Able - Proposed MEP, Killingholme

Associated British Ports (10015525)

Representations regarding additional information submitted by

Terrestrial Ecology

Figure 3
Breeding Birds Proposed Mitigation

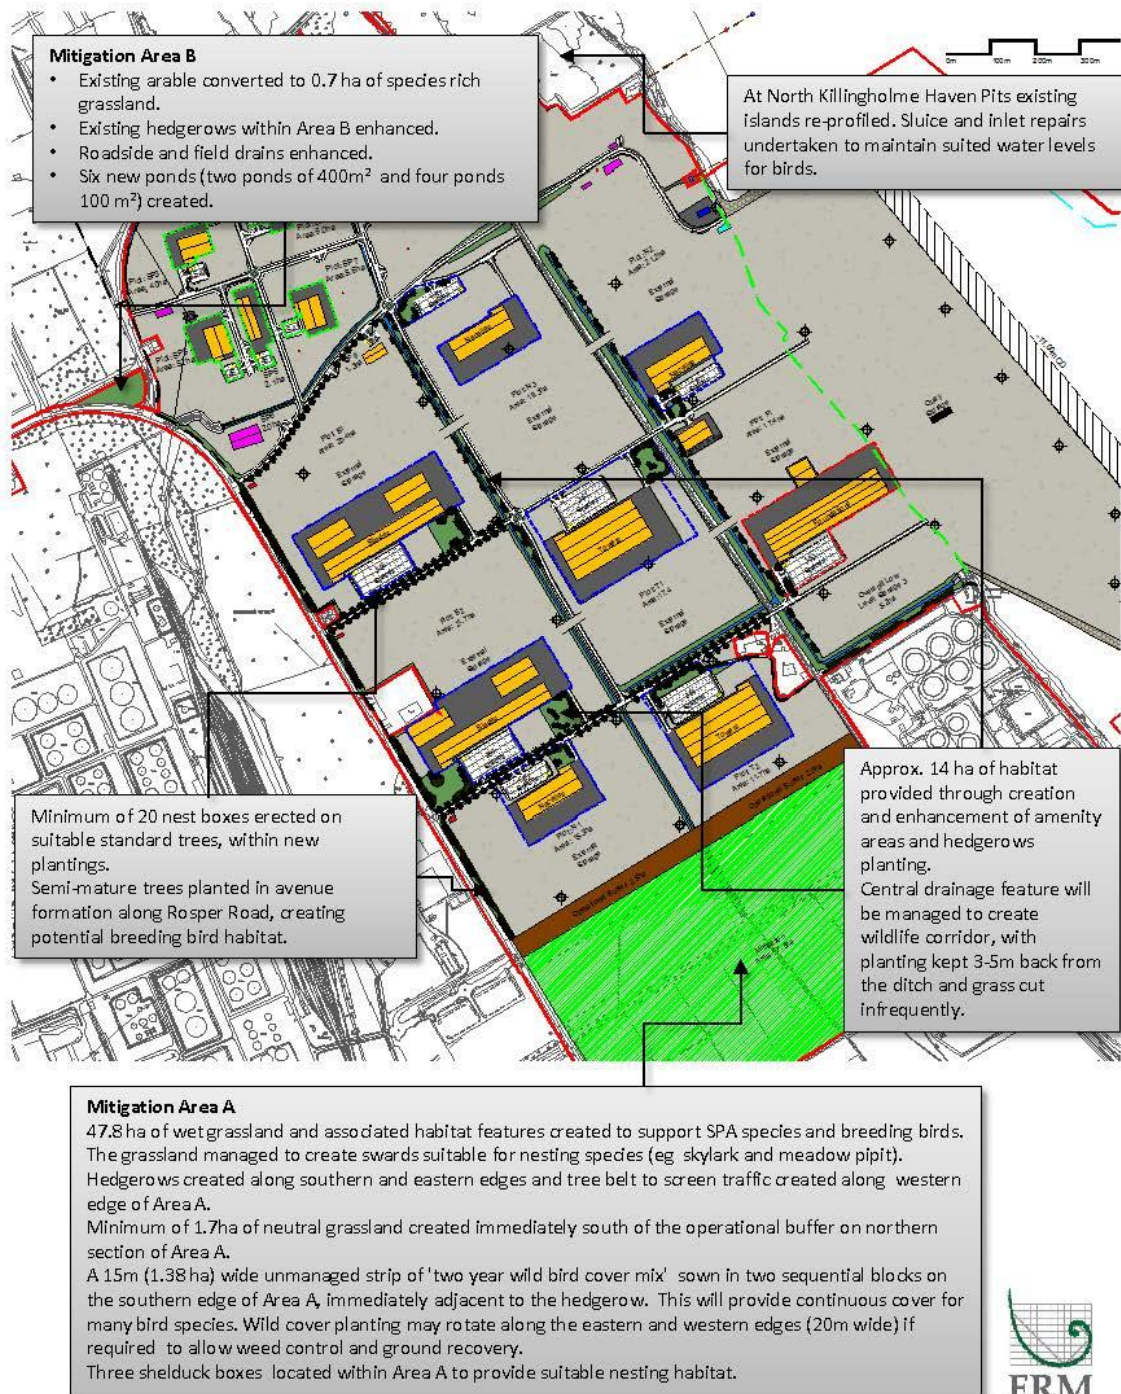
2. ABLE UK had been criticised by Natural England for its approach when assessing the impacts of the development upon breeding birds within the development site. The original figures used were based on assumptions of future use of the industrial areas by breeding birds once the development was in place. These assumptions could not be justified and revised figures have now been presented (see Table 1 on the unnumbered page at the end of EX11.27 Breeding Bird Mitigation (not to be confused with Table 1 on page 2 of the same document)).

3. ABLE has now revisited the numbers of birds that will be lost to the development. These figures are summarised here in Appendix 1. In many cases the losses are greatly increased. Taking Skylark as an example the loss of this species has increased from -13 to -28 breeding pairs. Skylark are a red list¹ species and of 'Medium' sensitivity yet more than doubling the loss of this species is still considered to be 'negligible' impact. No additional mitigation has been put forward to mitigation/compensate the loss of these breeding birds yet the assessment within the ES has not been updated.

4. It should also be noted that mitigation area (presumably Area A) currently supports 14 breeding pairs of Skylark. The change in management of Area A to wet grassland and rough grassland strip will mean that the area is not longer suitable for nesting Skylark. Instead of 28 pairs being lost the true figure is 42 pairs.

5. It is clear that the original assessment of the impact of the development on breeding birds was fundamentally flawed. The revised figures are still an underestimate and the mitigation/compensation is over optimistic and cannot be relied upon.

6. Finally the impact upon the breeding bird assemblage has still not been assessed. The original estimate of the total loss of breeding pairs of all species was 237 this has now been increased to 549 yet no attempt has been made to revisit the assessment presented within the EIA.
